STATEMENT OF ENVIRONMENTAL EFFECTS: SECTION 75W APPLICATION, MODIFICATIONS TO MAJOR PROJECT MP NO.10_0107 (BUILDINGS 3) – 61 MOBBS LANE, EPPING

The proposed amendments pertain to minor design changes applicable to Building 3 only.

A-3008 A
Project Application

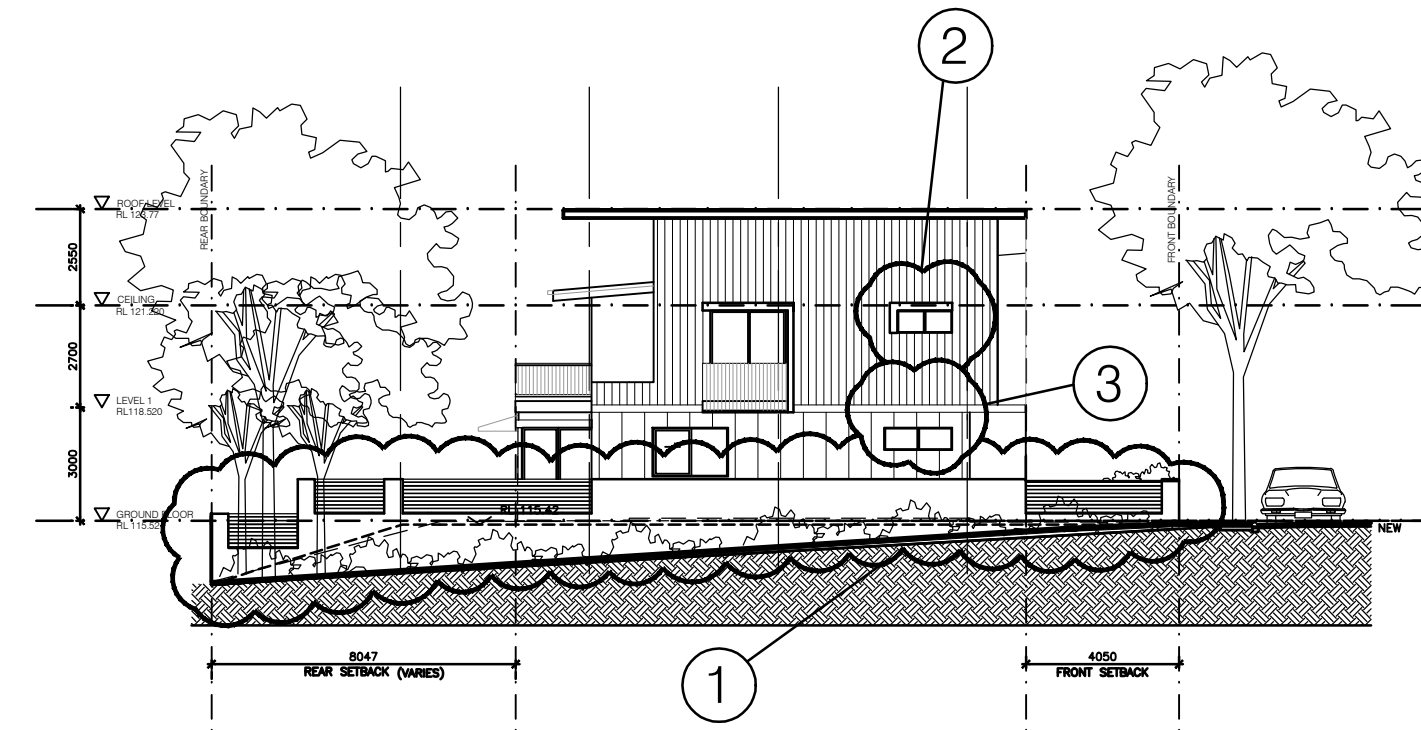
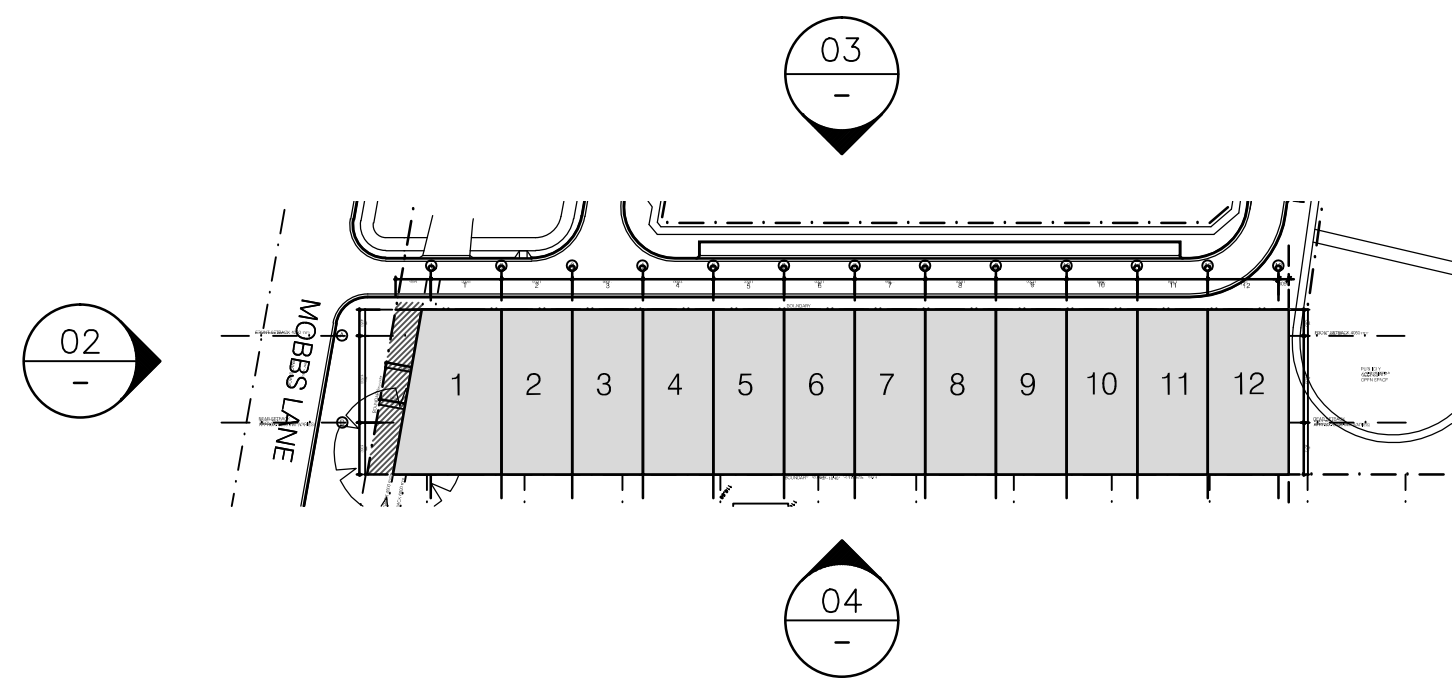
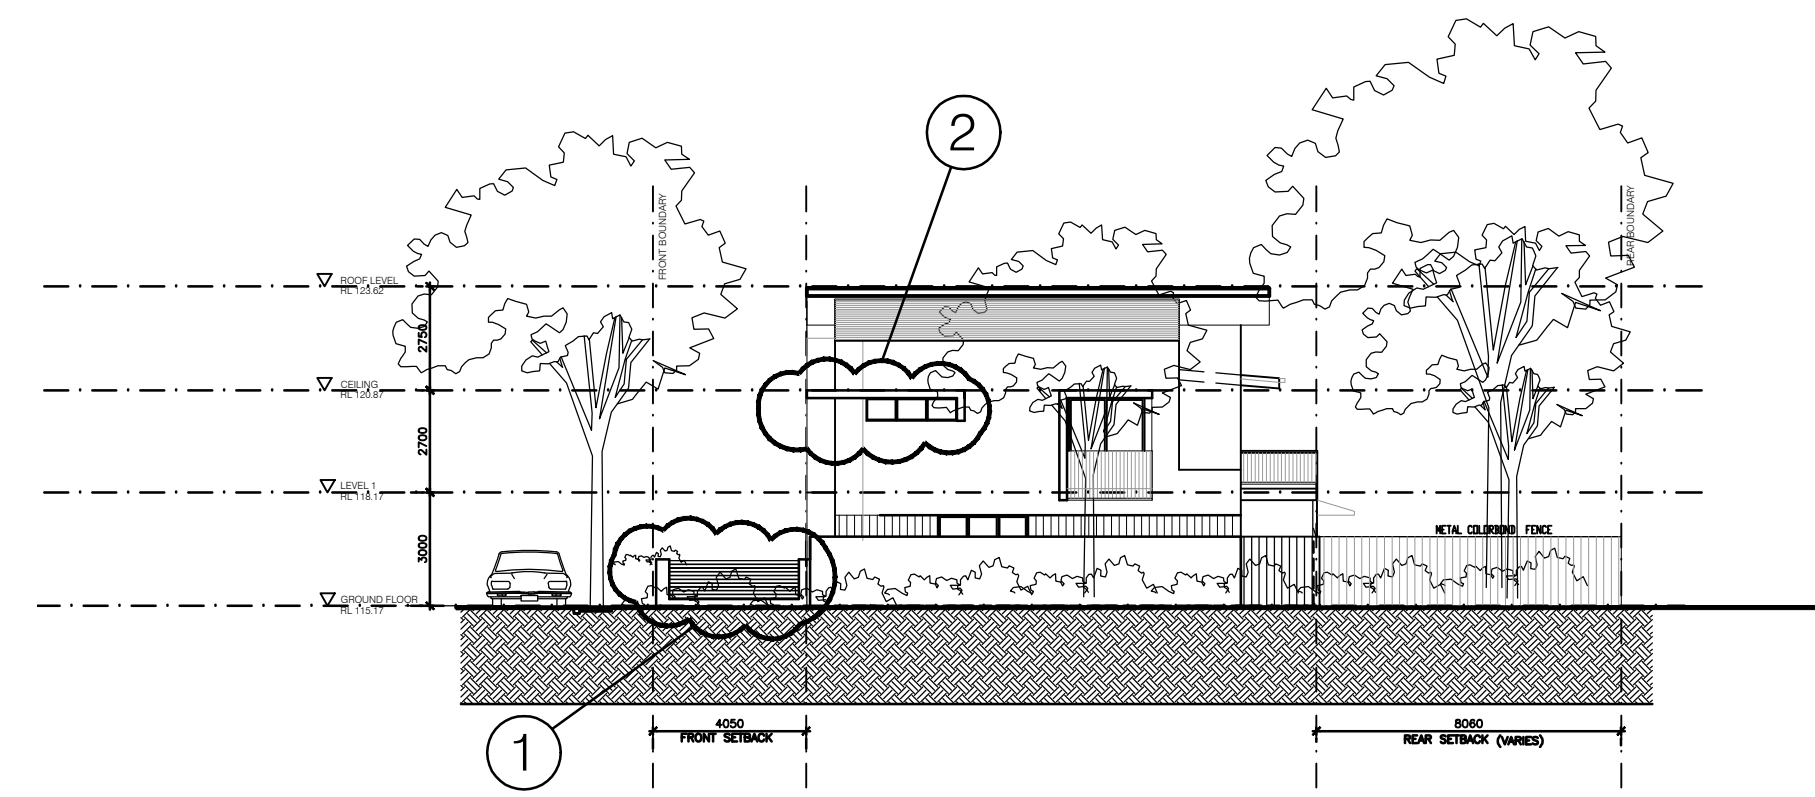
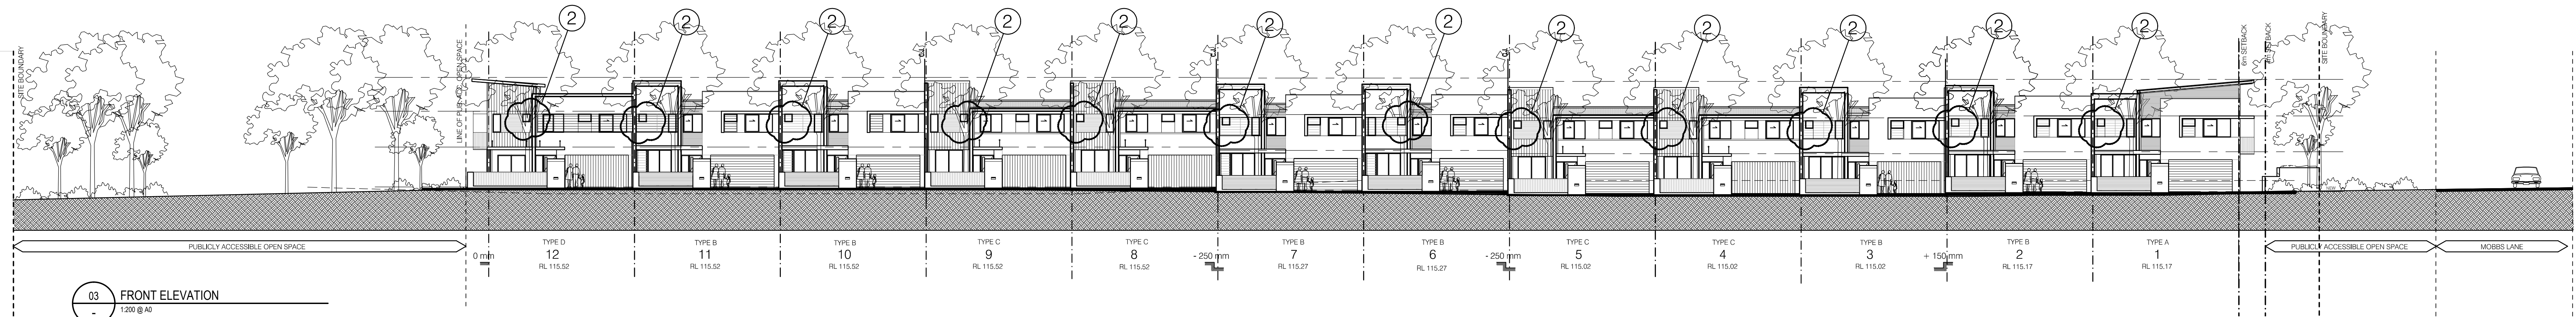
The modification seeks to provide a window abutting the proposed open space and increase the height of fencing for improved privacy.

The additional window will improve light and air into the end townhouse, whilst the fencing height will improve privacy from the other residents passing the internal street.

Building 3 Existing Approval	Building 3 Proposed Modification (Numbering as per the legend on the submitted plans)
A3008 Side Elevation	A3008/A Side Elevation 1. Fencing detail changed 2. Window reconfiguration
A3008 Front Elevation	A3008/A Front Elevation 2. Window reconfiguration
A3012	A3012/A 3. New window
